REPORT UPDATE

Application No: FP/249/18/PL

LOCATION: 22 North Way
Felpham
PO22 7BT

PROPOSAL: Replacement of existing bungalow with 1 No. chalet bungalow (to approved design FP/259/17/HH).

DRAWING
LOCATION PLAN
SITE PLAN
DRAWING No
236/01
SCALE
DATE 1:1250 1:500
OCT 2017
REVISION
DRAWN
CHECKED
LA

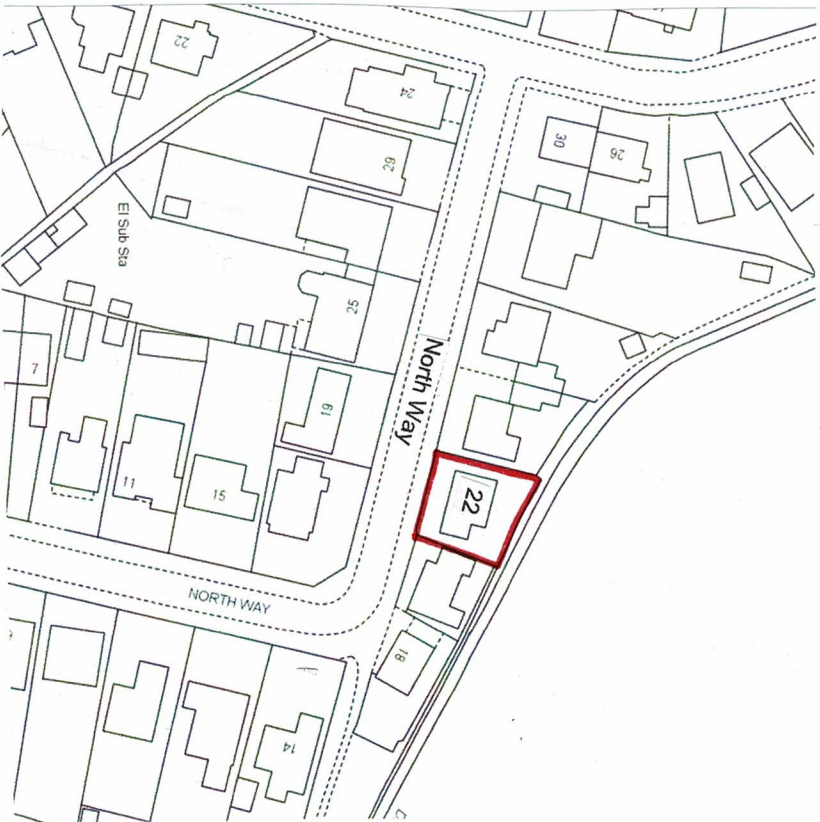
No identification of car parking on the block plan or submission made under FP/259/17/HH.
Two parking bays proposed are 2.15m wide by 6.45m long (a standard UK car parking space is 2.4m by 4.8m) - the Council feels that the space to park cars in parallel format as could not be achieved.
Difference in the ground and first floor lay outs/plans which indicates this is not the same as approved.
Therefore object to the parking issue and that FP/249/18/PL is not to the approved design or details provided in FP/259/17/HH.

The proposal accords with Local Plan D DM1 and with policies ESD1 and 8 of the Neighbourhood Plan. The proposal remains not to fully comply with policy ESD10 in that although the position of cycle and bin stores are shown(plan 236/01), other details are not. The missing details are not considered necessary at the planning stage. It is not considered that non-compliance with this policy should result in a refusal.

Location Plan - 236/01 (with the exception of parking details)

The parking arrangement is similar to FP/259/17/HH where officers concluded "Although it is considered that there is limited amount of space for on-street parking due to existing vehicle accesses and crossovers and given the opportunity to park on both sides of the street, it is not considered that such matters are so severe as to merit refusal of permission and the proposed development would not conflict with GEN7 and GEN12 of the Arun Local Plan 2003." Following the adoption of the Local Plan July 2018 the above policies requirements of TSP1 superseding the previous Arun Plan Policies .

PROPOSED SOUTH ELEVATION 1:100

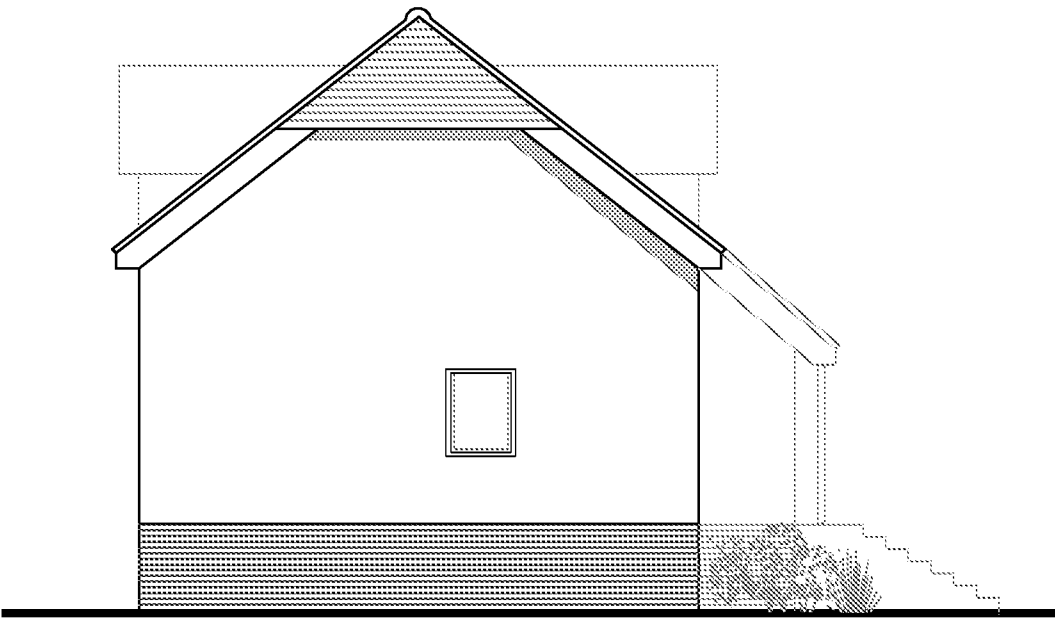
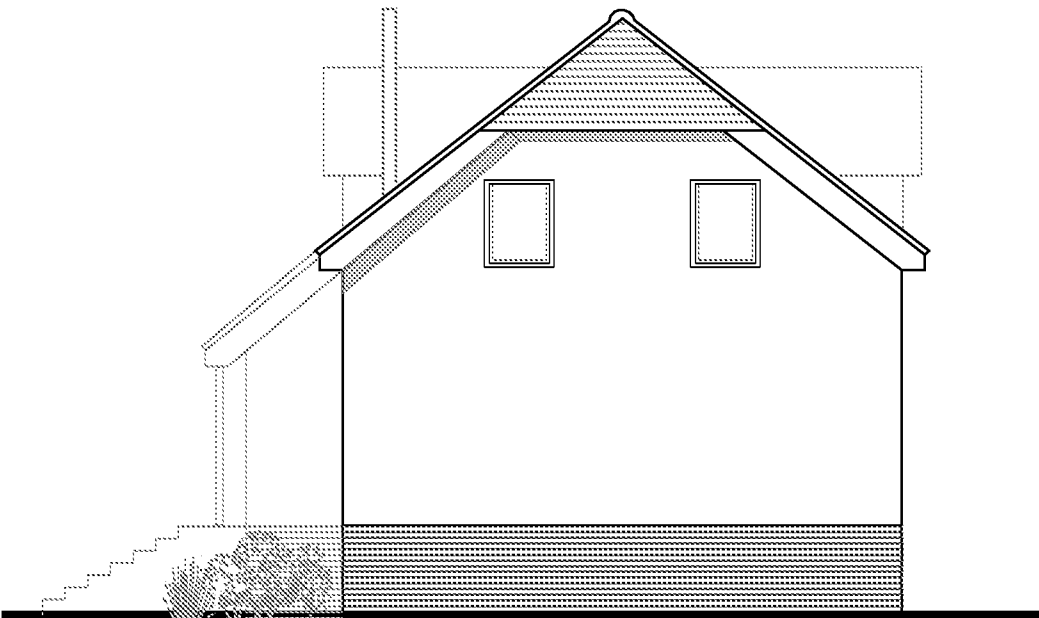
There is no loss of privacy to existing properties, namely no.20. Although two side 1st floor windows (serving bathrooms) appear in the side elevation, the rear garden at no.20 is occupied by an amenity space set away from the shared boundary. The siting of the dwelling has been designed to mitigate further harm to neighbouring occupiers. Its form prevents demonstrable harm caused by loss of light.

Reason: To provide adequate on-site car parking and turning space for the development and in accordance with the National Planning Policy Framework.
- 5 The proposed first floor en-suite windows on the east elevation of the building shall at all times be glazed with obscured glass.
